REPORT UPDATE

Application No: M/26/10/

LOCATION: 32 Ancton Way
Elmer Sands

PROPOSAL: Demolish existing prefabricated bungalow and build new 3 bedroom house

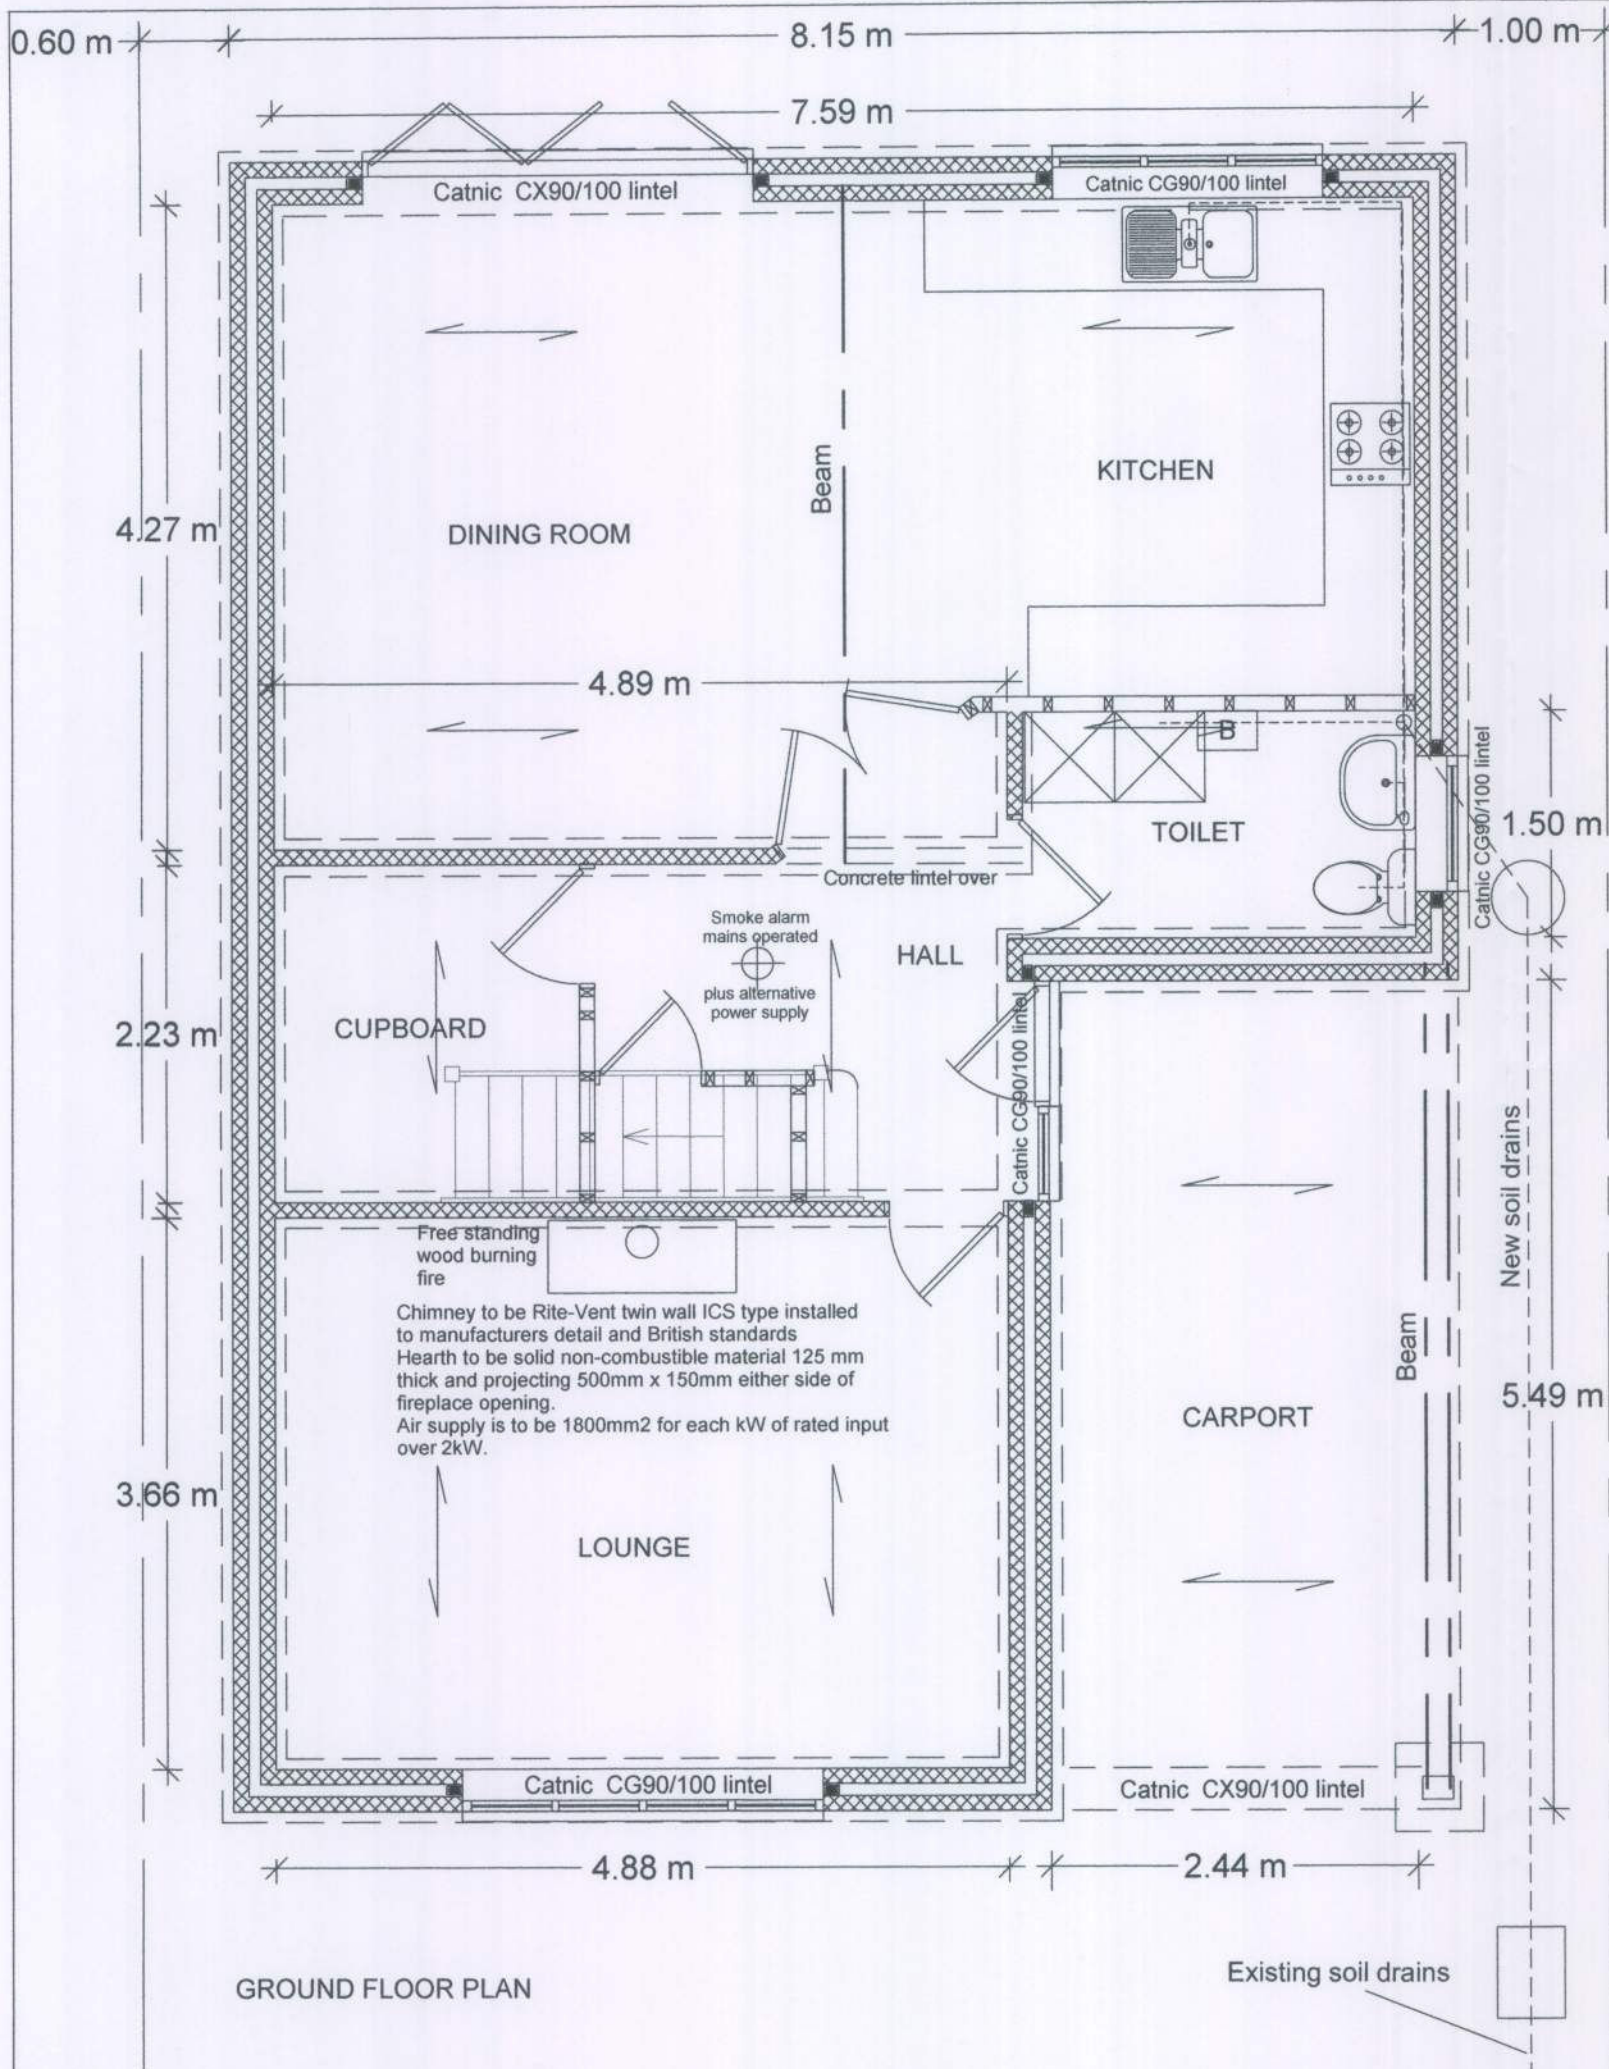
The proposal is to raise floor levels 600mm to mitigate against potential flooding. The application states that this is in accordance with the Environment Agency requirements.

Noted. The applicant has raised the floor levels accordingly.

EAST ELEVATION

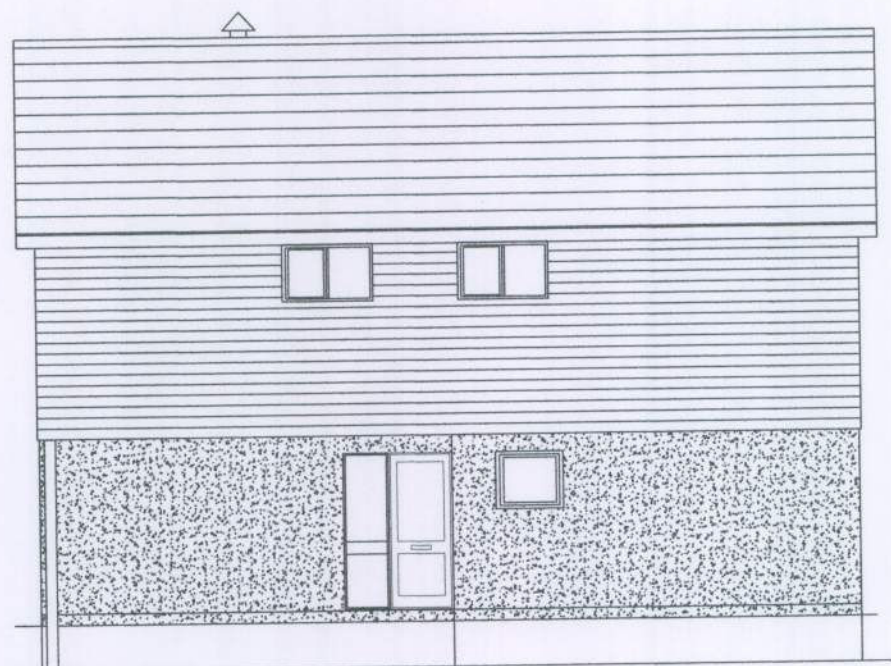
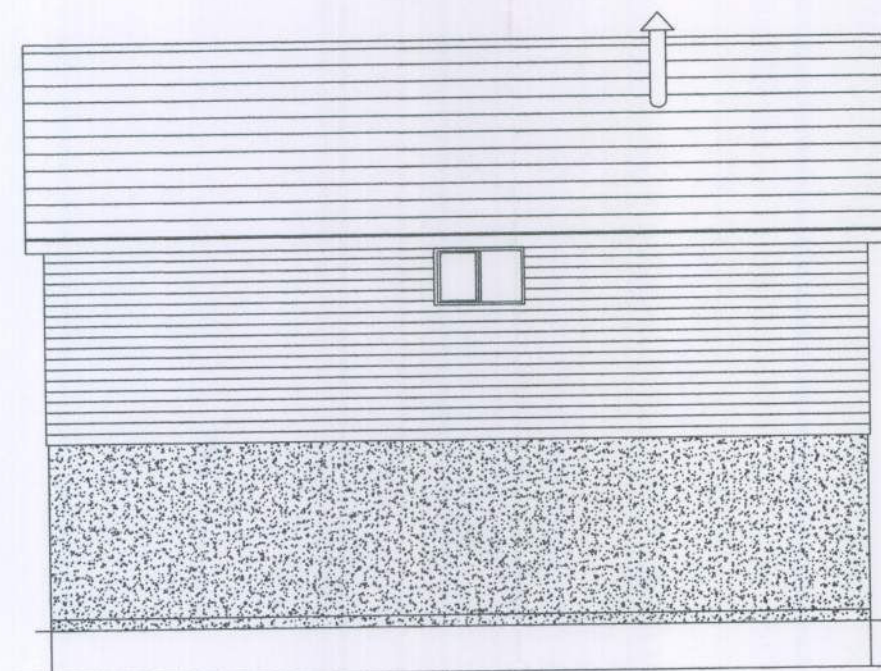
A first floor side window will directly overlook neighbour. The garden of neighbour will be in the shade.

to the contemporary standards. It is not considered that the replacement dwelling would significantly add to the existing drainage problems. The adjacent property is a bungalow therefore there is no direct overlooking of windows at first floor level. It is not considered that the dwelling would significantly overshadow garden areas. There is sufficient parking areas to the front of the dwelling.

The proposal is for a house and the properties either side are bungalows. The proposal is for one side first floor window which is for a landing and two bathroom windows on the east elevation. Therefore there is no loss of residential amenity to neighbouring properties for overlooking. The dwelling has a one metre side boundary either side and it is considered that the proposal would therefore not be significantly overpowering or create any significant overshadowing.
